CITY OF ALBUQUERQUE

July 23, 2018

RE: **Juan Tabo Hills Park**
Grading and Drainage Plan for SPBP – Disapproved
Engineer's Stamp Date: 7/16/2018 (M22D017A)

CITY OF ALBUQUERQUE STRATEGIC PLANNING AND DESIGN PARKS AND RECREATION DEPARTMENT	
JUAN TABO HILLS PARK - PHASE 1 GRADING AND DRAINAGE PLAN - SOUTH	
Design Review Committee	City Engineer Approval

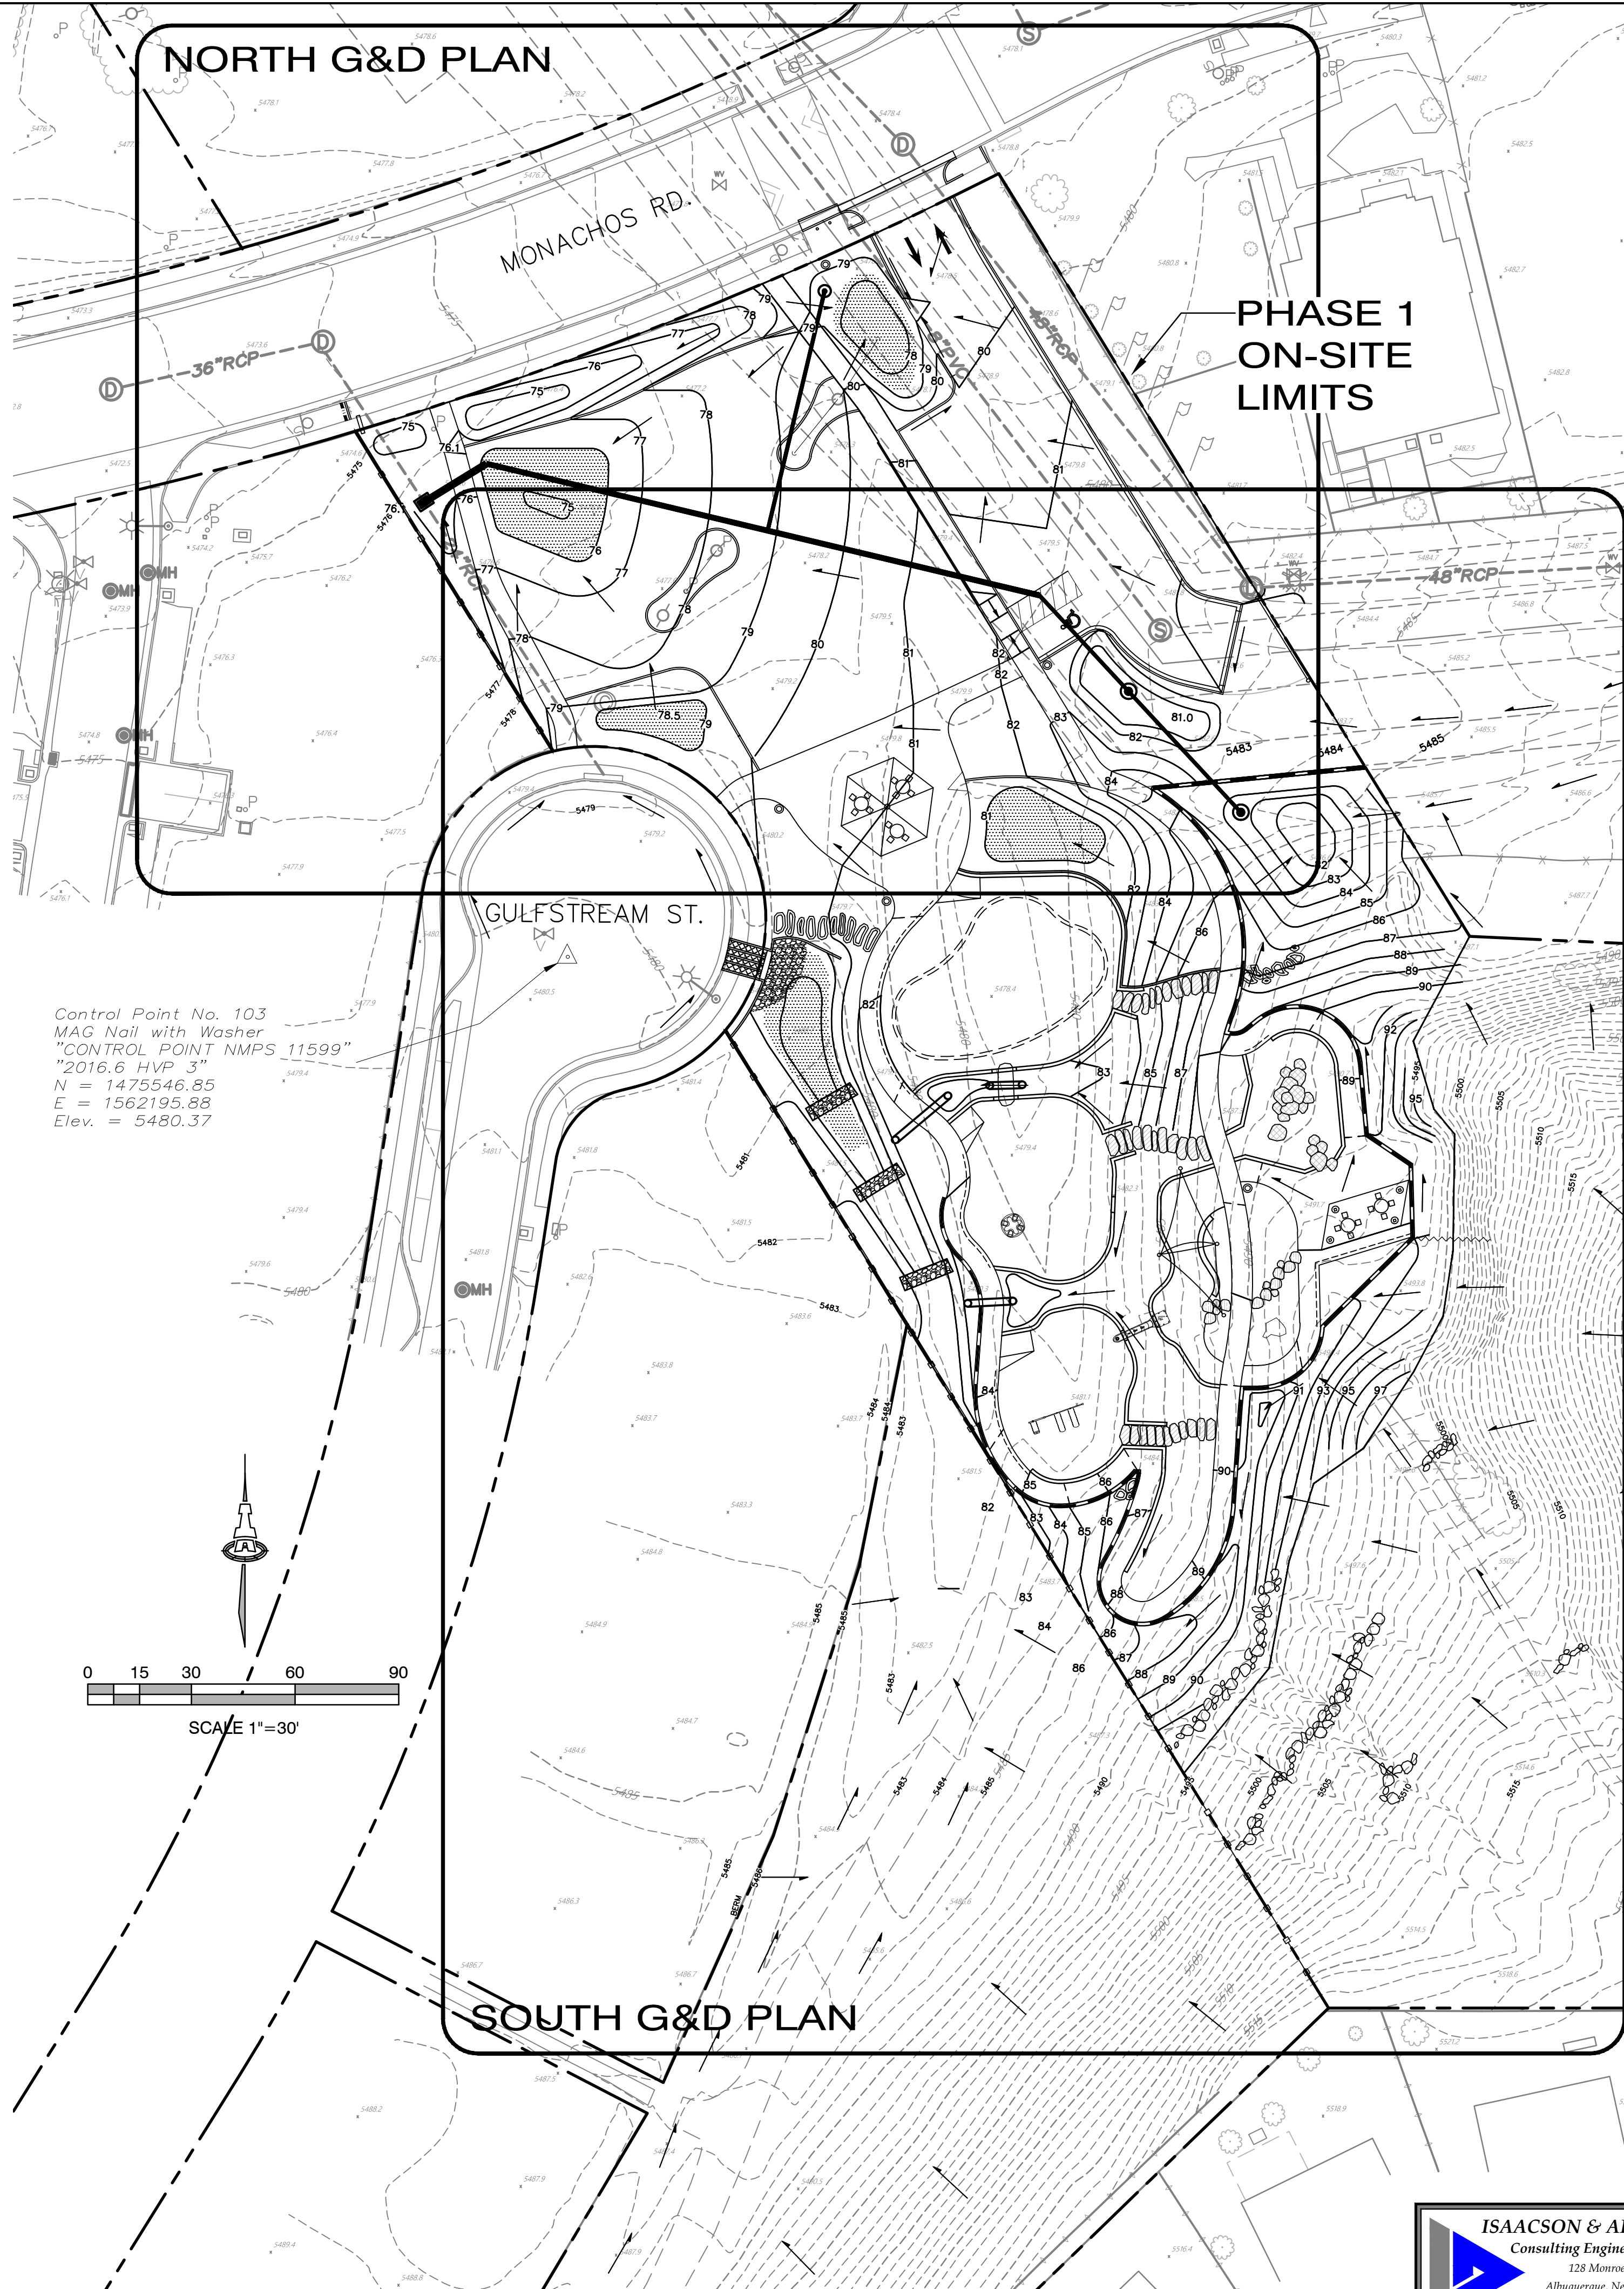
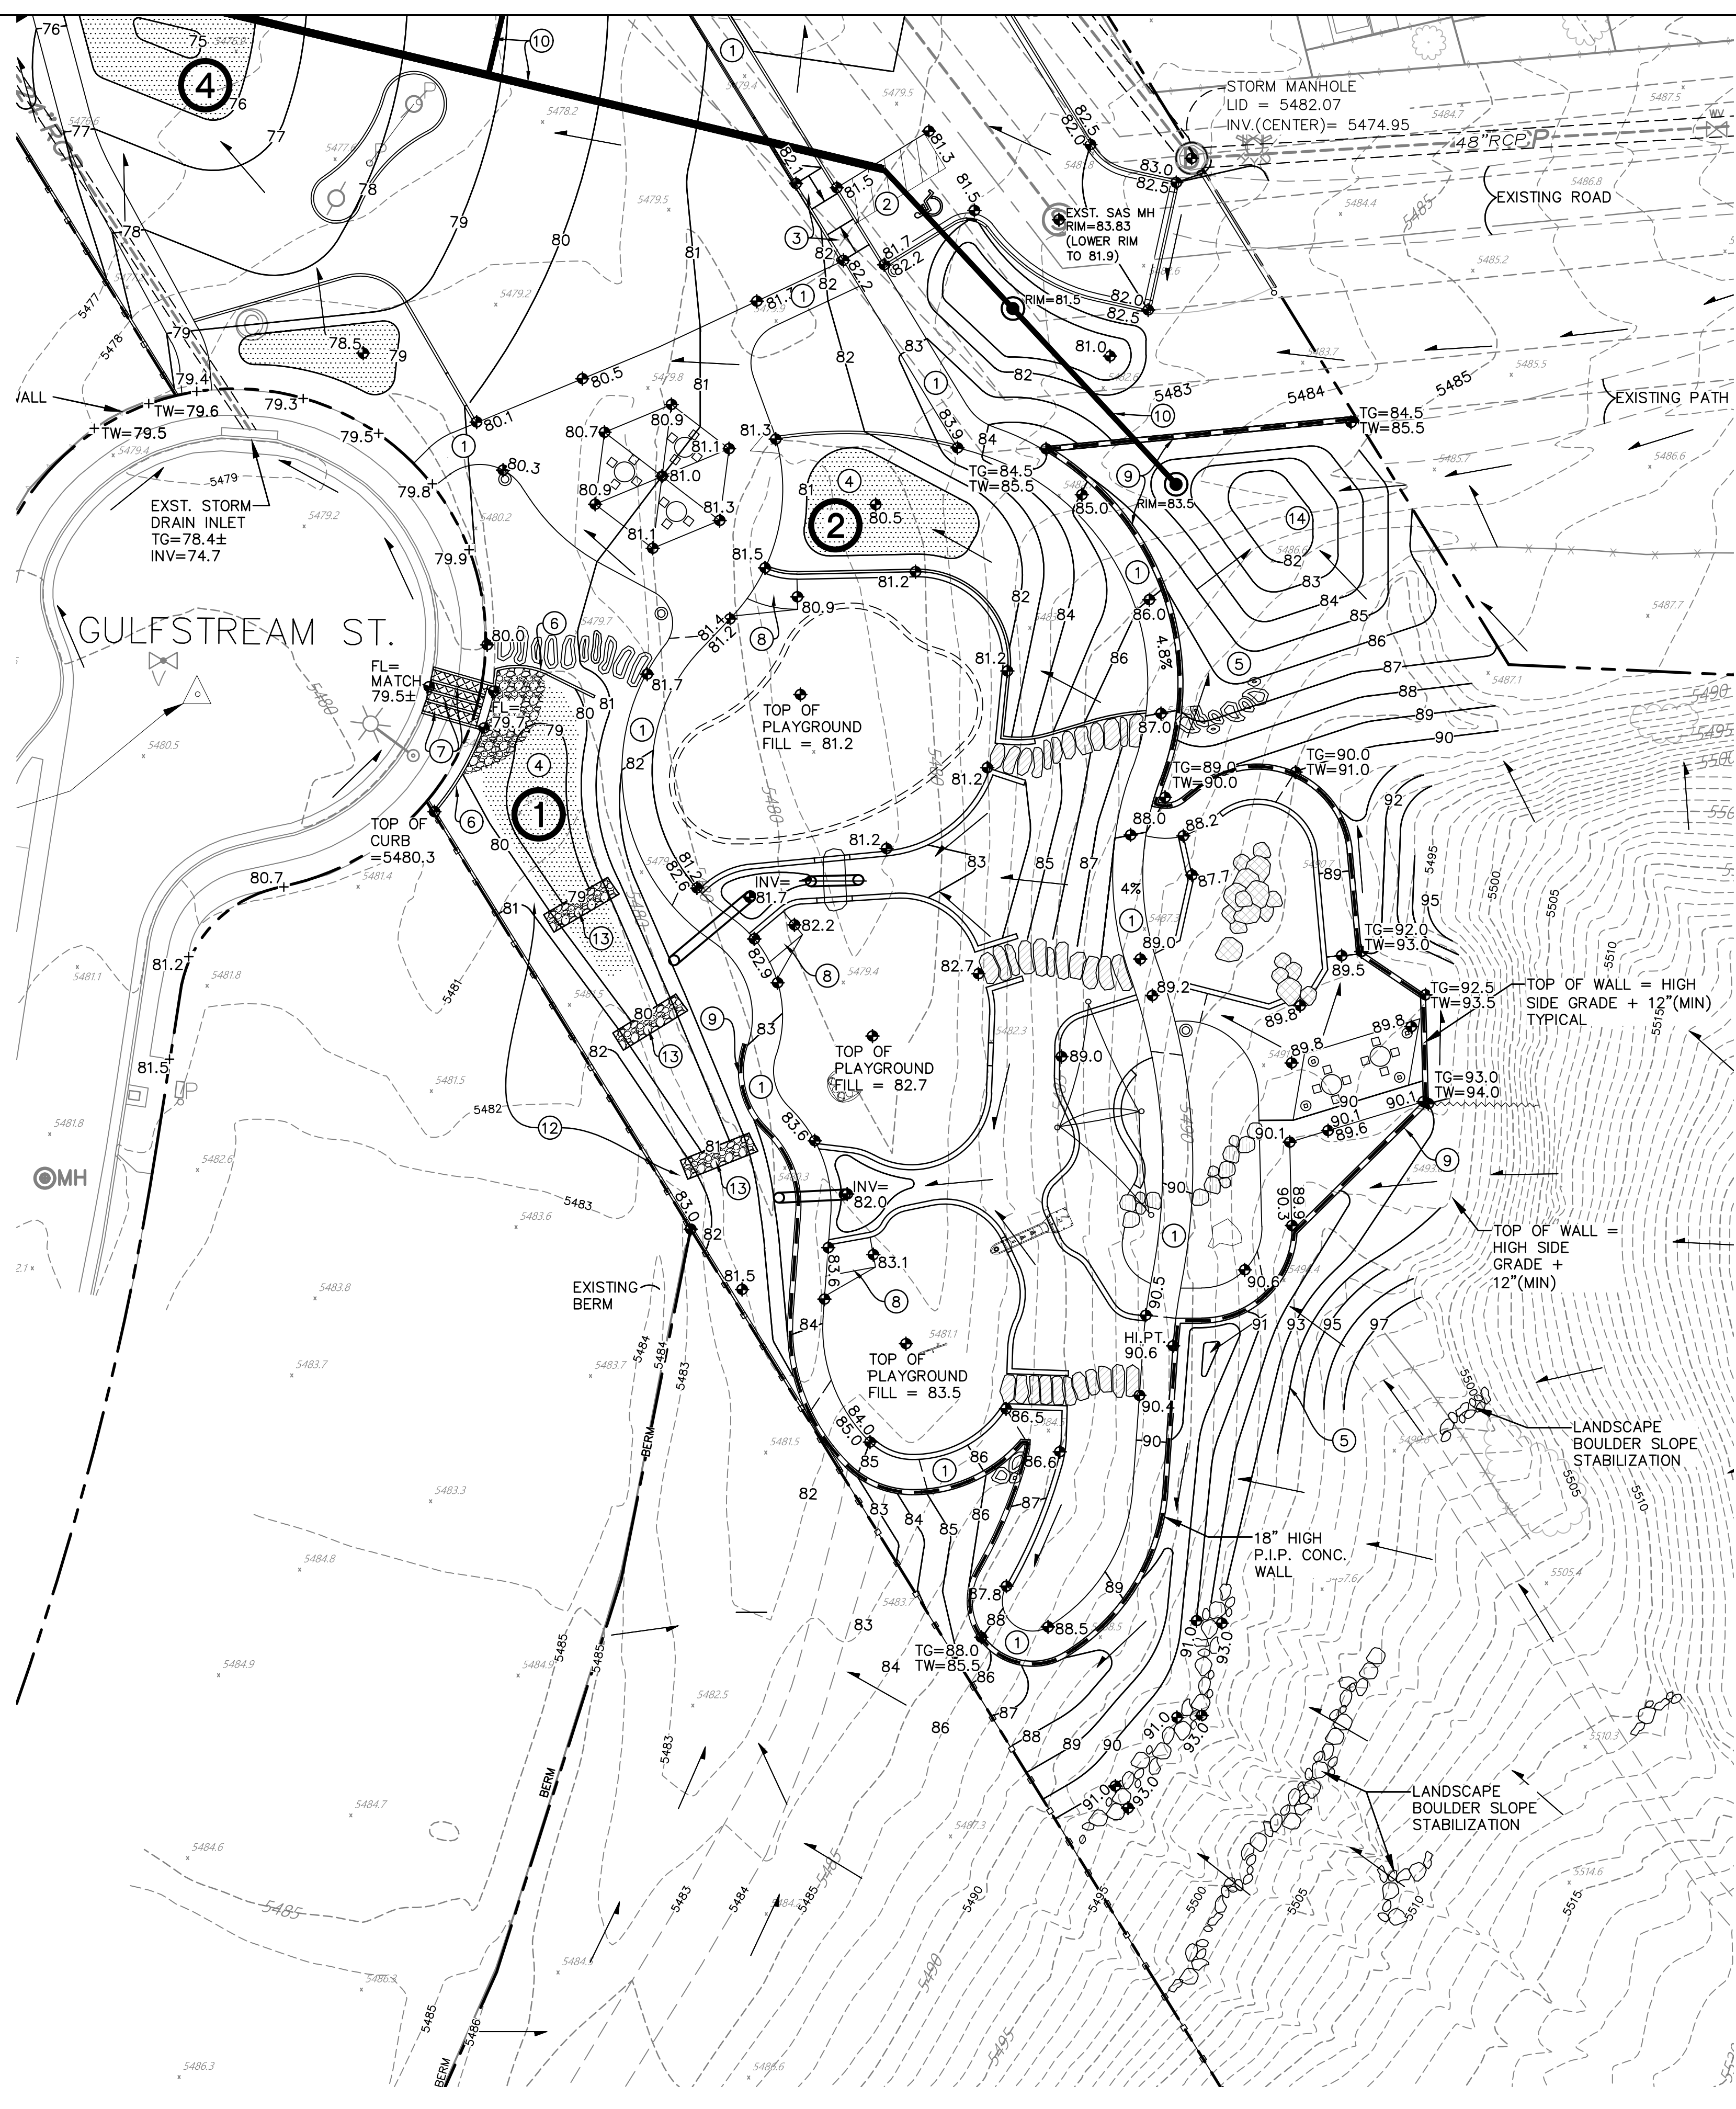
2. The layout must be revised so that the swale on the southwest side of the site remains unobstructed. The Playground includes more than 3' of fill in the swale, which may force drainage from the swale into the private lots west of the park. The playground may need to be shifted east to avoid blocking the swale. Capacity calculations are required for the swale, and must include 1' of freeboard.

3. Either provide written permission from the owner of the lot to the southwest for the grading that is shown on their property or delete the grading from the plan. Volume calculations and a Drainage Covenant are required for the pond if it remains on the G&D Plan.

4. The Gulf Stream cul-de-sac was not originally designed to receive any drainage from this site, but it may have extra capacity for some of the drainage from the pond just east of the Cul-de-sac. Pond design calculations are required, including an emergency overflow path. If the path is into the cul-de-sac then the capacity of the downstream system must be checked.

5. Capacity calculations are needed for the swale running down the west side of the park between the Gulf Stream cul-de-sac and Monachos Rd. to insure that drainage does not cross into the private lot west of the park.
